**WARWICKSHIRE COUNTY COUNCIL  
(20040686)**

**Hinckley National Rail Freight Interchange**

**Written Representations  
October 2023**

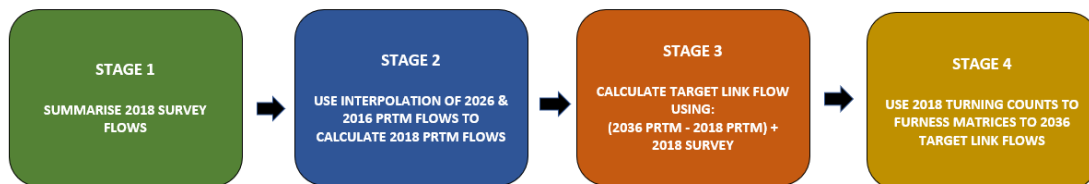
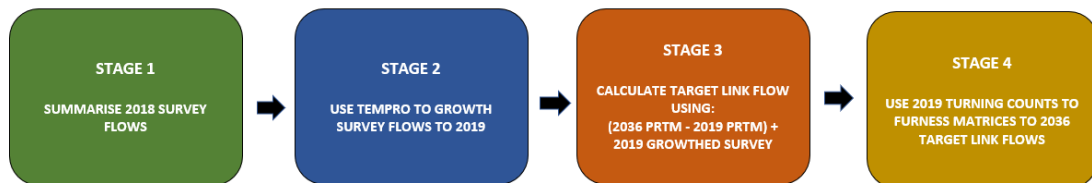
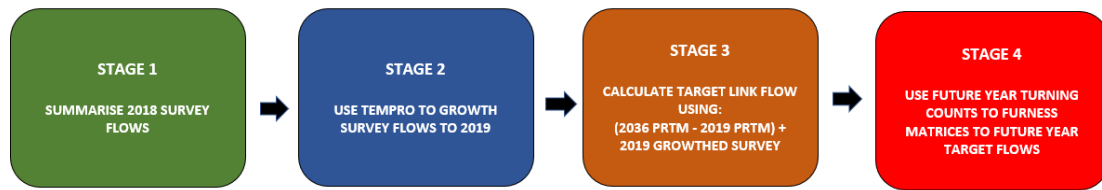
- 3.13. Further to this issue being raised, a Technical Note has been submitted to the Examining Authority. This sets out the furnessing methodology, and whilst helpful with the detail provided, there are some outstanding queries that need to be addressed, for instance the treatment of turning movements which were observed to be zero or close to zero. It is understood that this matter has been raised by National Highways with the applicant team and will be discussed further following the submission of documents required for Deadline 1 set out in the Timetable within the Rule 8 letter.
- 3.14. As a consequence of these two issues, the PRTM outputs have not been agreed by the Highway Authorities.

Drawing file: TR050007 / TR050007-002505-Hinckley NRFI Appendix 14 - Gibbet Hill Mitigation General Arrangement.pdf

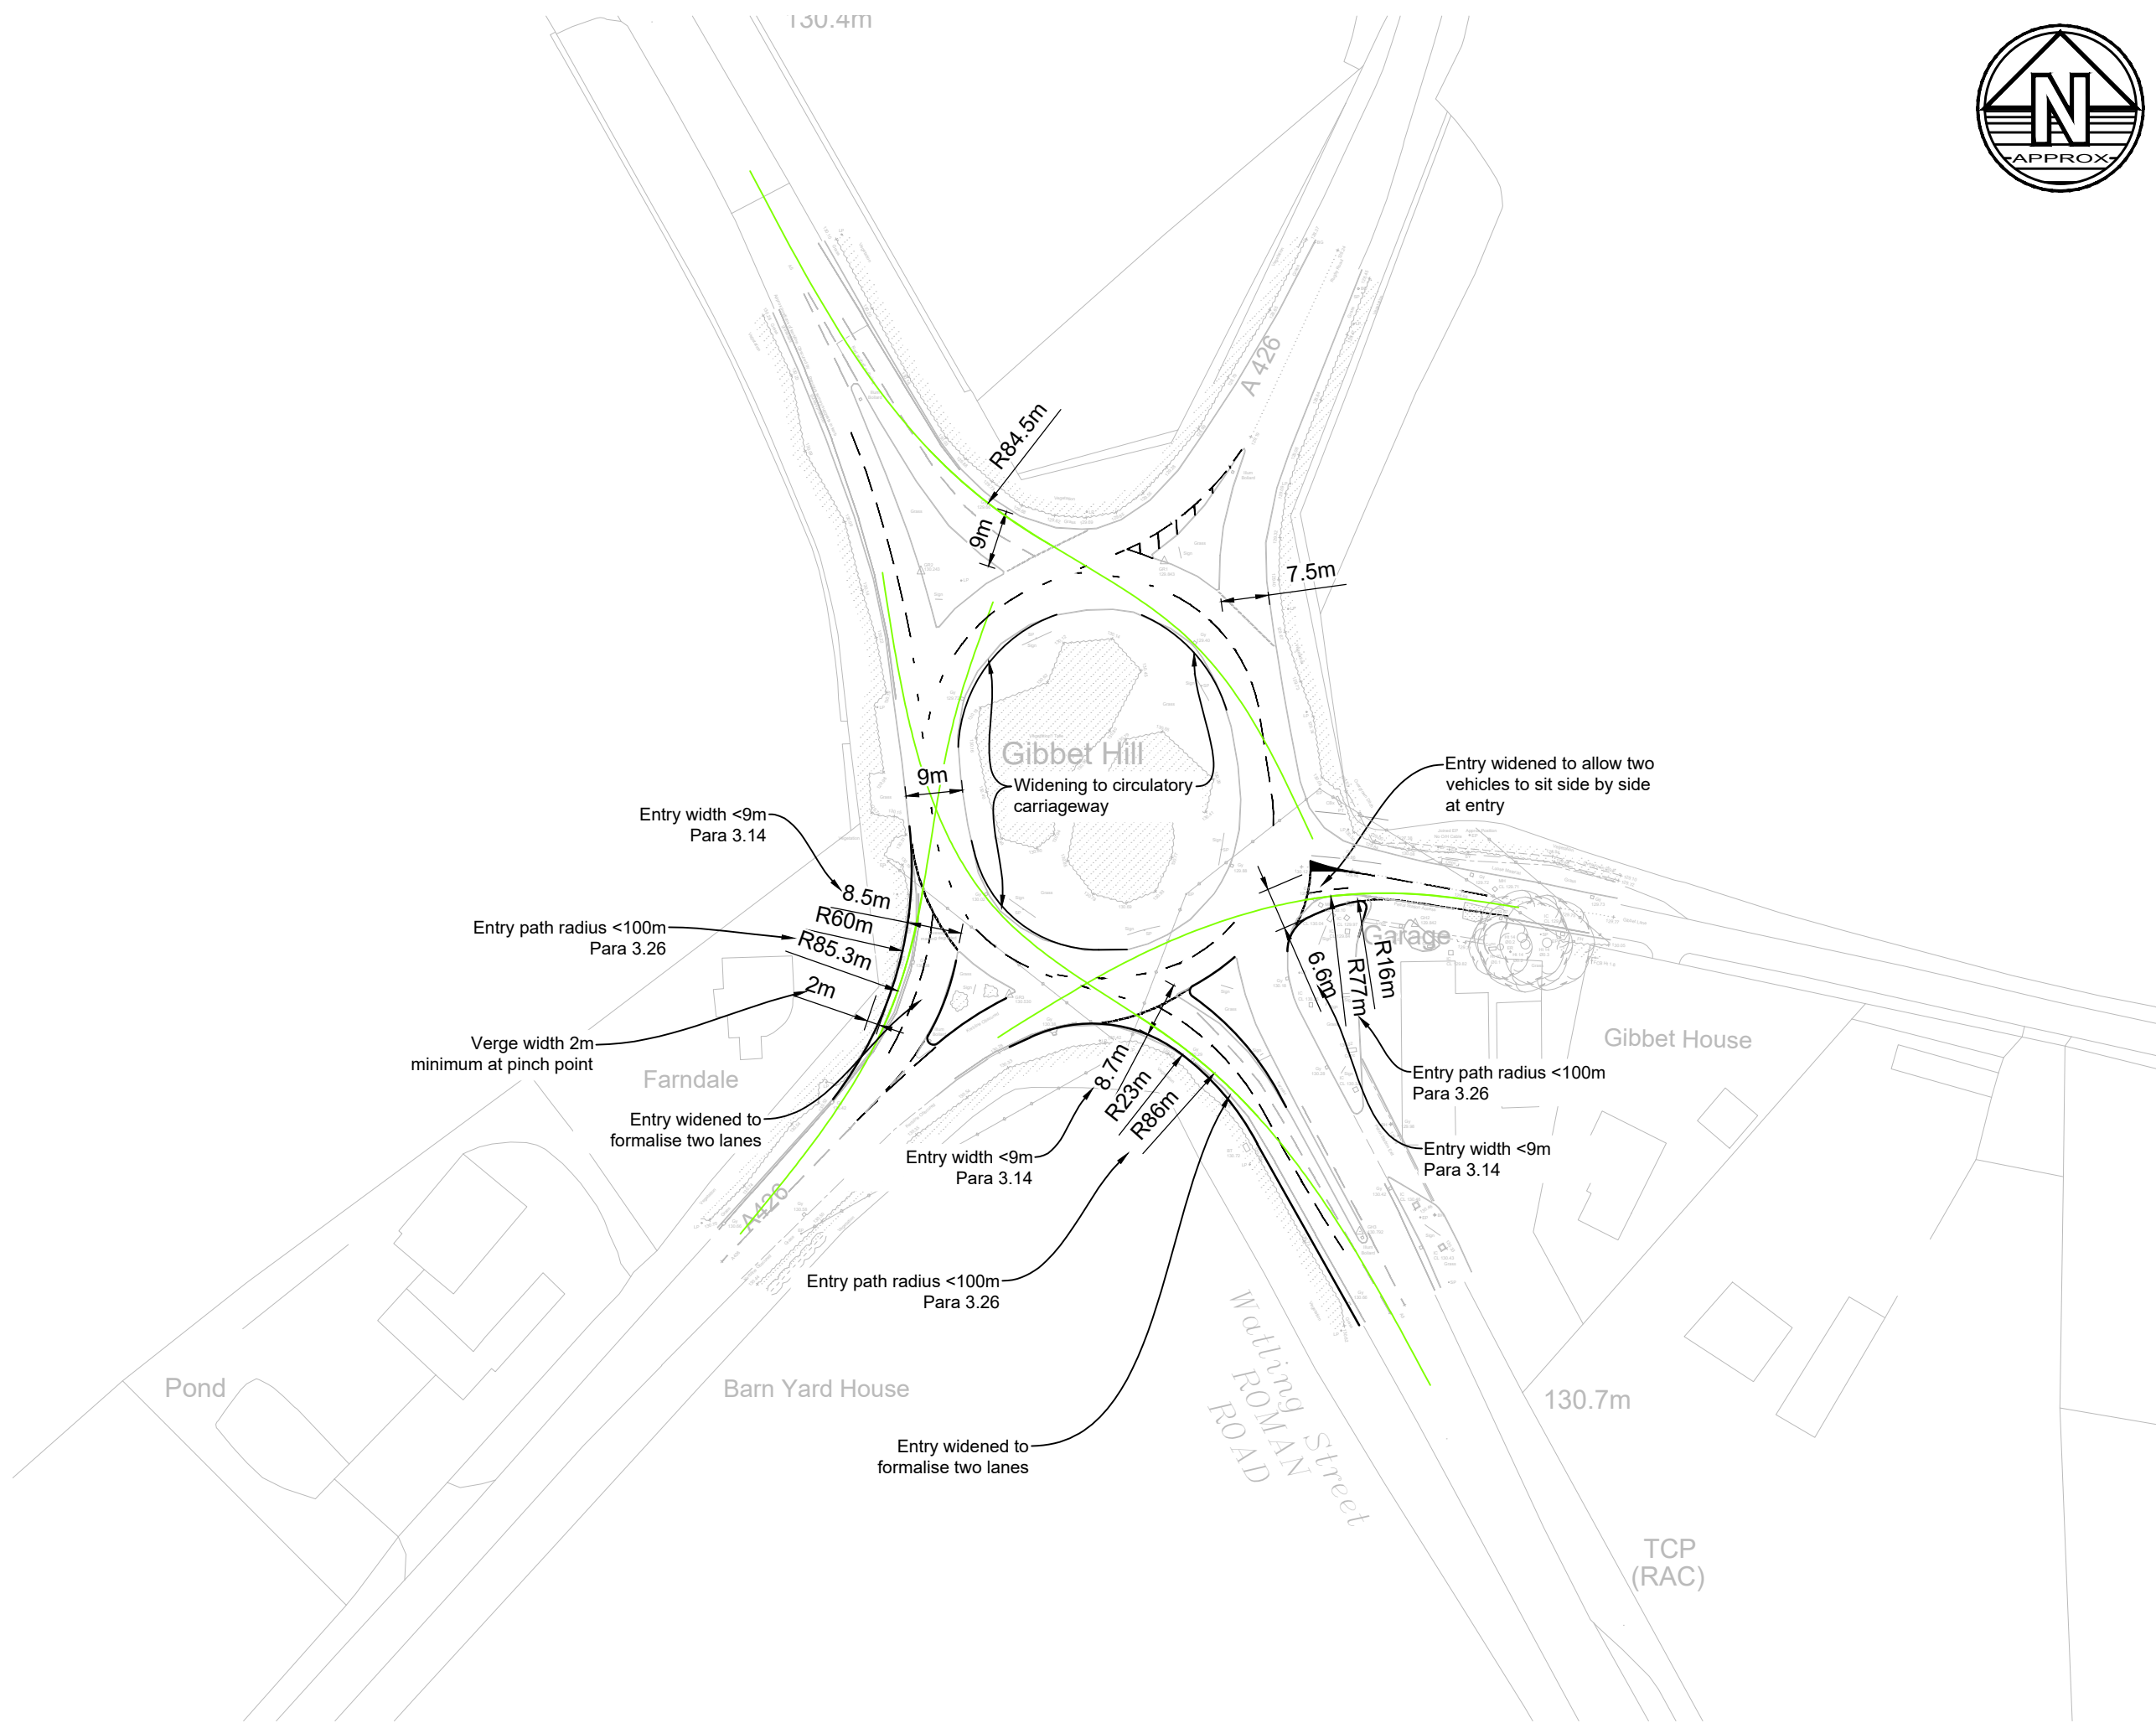
- 3.18. National Highways considered the junction signalisations proposals and recognised that due to these committed developments and other Local Plan led growth in the area, the proposed signalisation scheme will not accommodate the cumulative impact of various consented developments. As a consequence the traffic signal scheme assessed as part of the Hinckley National Rail Freight Interchange Transportation Assessment is no longer proposed.

3.20. Furthermore, the queues and delays forecast in the LinSig assessment for the proposed traffic signal junction (with the Hinckley National Rail Freight Interchange traffic) are significantly lower than those in the VISSIM model (without the Hinckley National Rail Freight Interchange traffic).

3.22. Therefore for these reasons Warwickshire County Council does not accept the modelling or proposed mitigation at this location, and requires the VISSIM modelling to be carried out.
